One Earth Solar Farm

Final Statement of Common Ground with West Lindsey District Council

EN010159/APP/8.4.5

December 2025

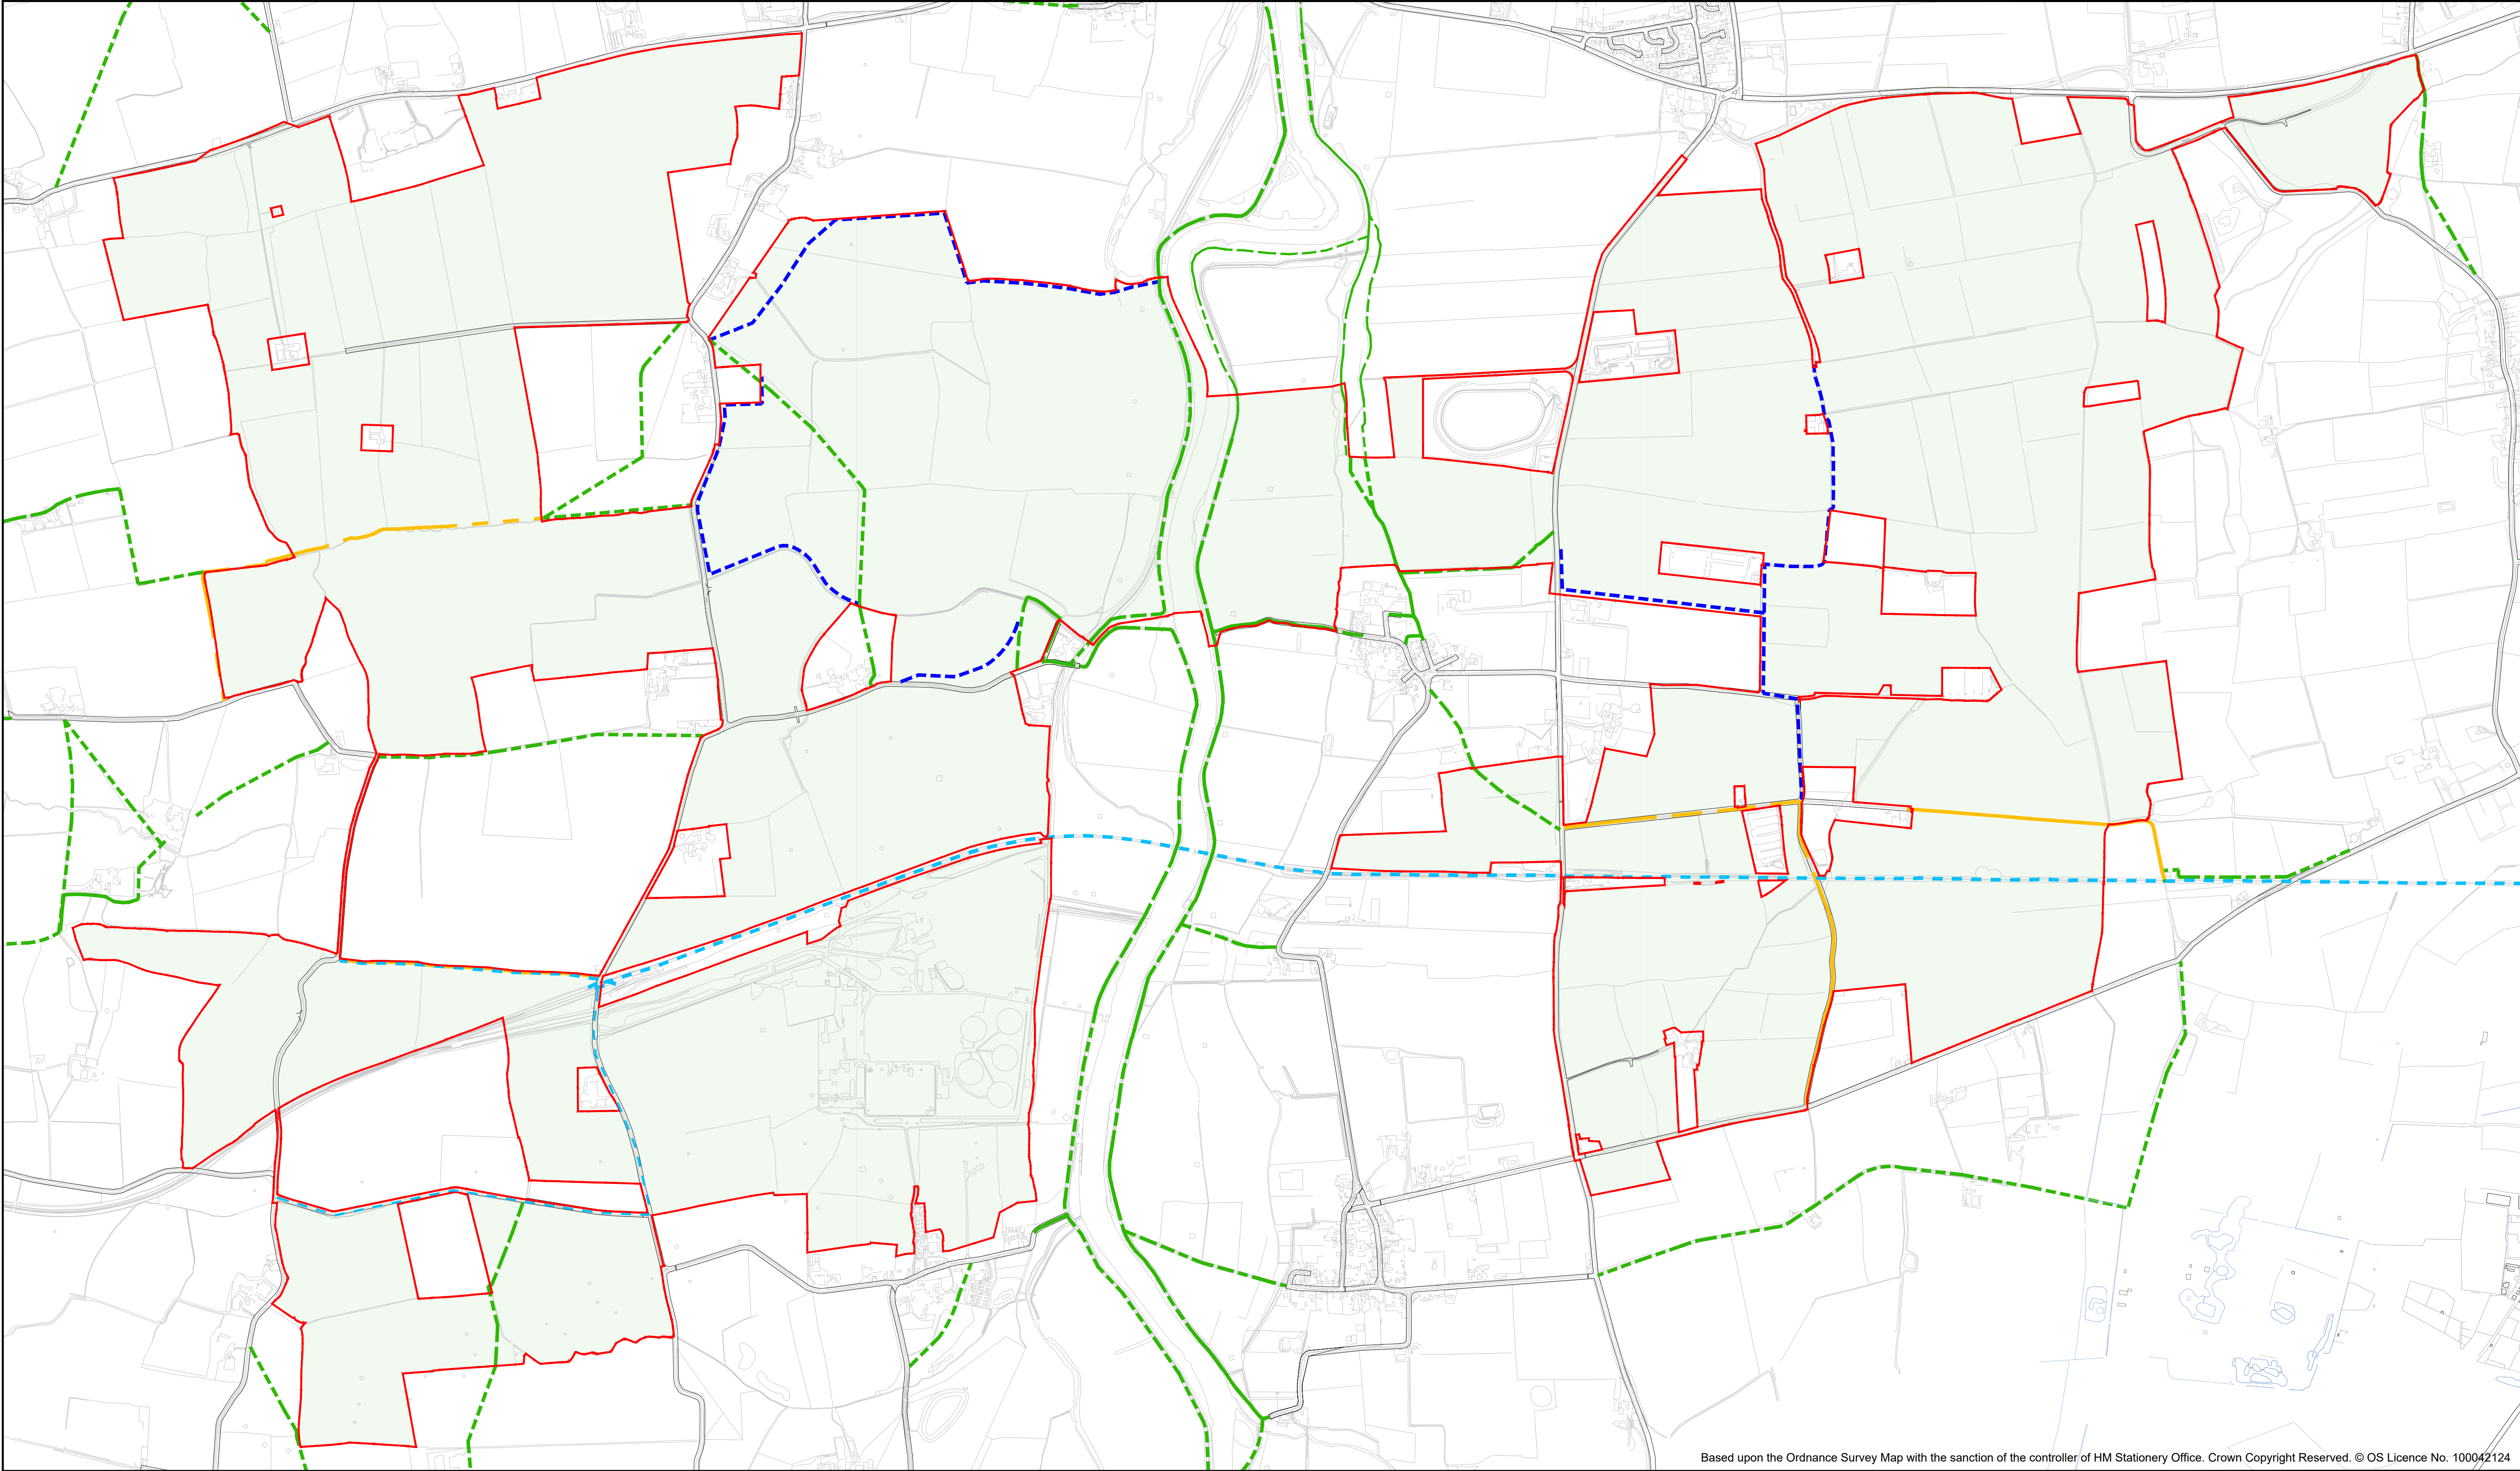
<p>WLDC request the glint and glare mitigation fencing is added to the mitigation plan in Appendix A of the OLEMP.</p>	<p>Which references the glint and glare assessment which shows the location of these fences.</p>	
--	--	--	--	--
